## Application for a Non-Material Amendment Following a Grant of Planning Permission

Alterations to include erection of first floor and two storey extensions along with a replacement single storey extension. Works to include increase of hard surface to the existing driveway.

23/00089/HHD

2206 24A North Elevation as Proposed

NORTH ELEVATION - AS PROPOSED 1:50@A3

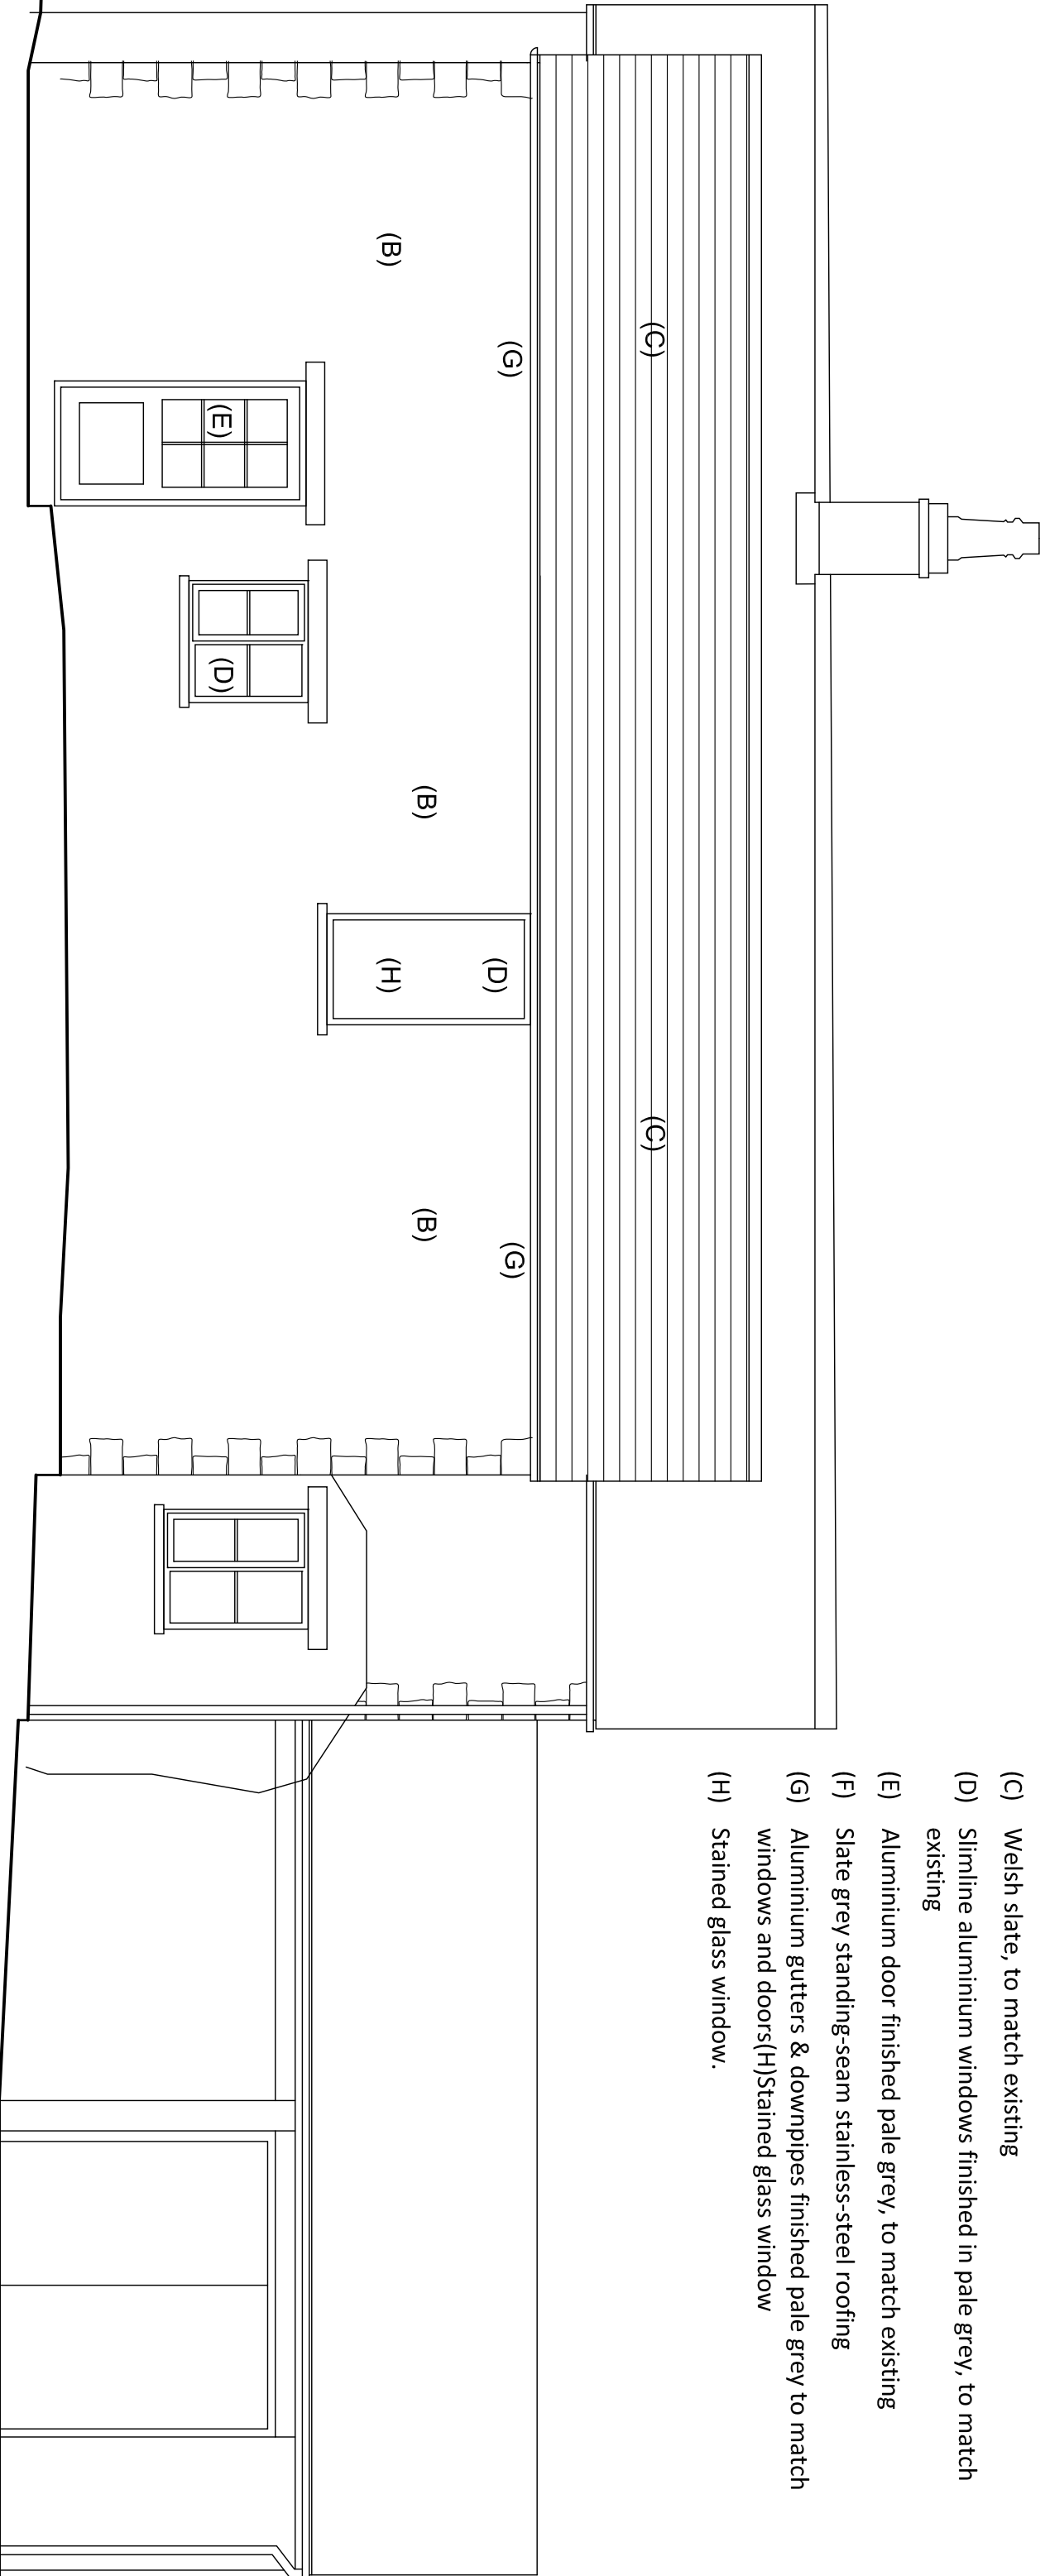
The north wall of the extension was proposed as being rebuilt with coursed limestone blocks with ashlar quoins, to match existing. We wish to amend this to being cream-coloured render, with ashlar quoins.

The reason for wishing to amend the proposed finish of the north wall back to cream coloured render, is that now that we have been investigating the structure of the hallway, cloakroom, utility room and bathroom area north wall, it is not going to be possible to give it an external finish of coursed limestone blocks without completely taking down the wall and rebuilding it. Consequently, retaining the existing rendered wall is a much more sustainable option. If the north wall can remain as rendered, then when it is extended, the whole north wall can all be rendered. The change from coursed limestone blocks to cream coloured render will still be within the palette of the existing materials and is in line with Design Guide 14 for extensions and alterations. This amendment to the appearance of the north wall should not affect the visual amenity of the neighbouring properties and as such will be a minor change from the approved scheme.
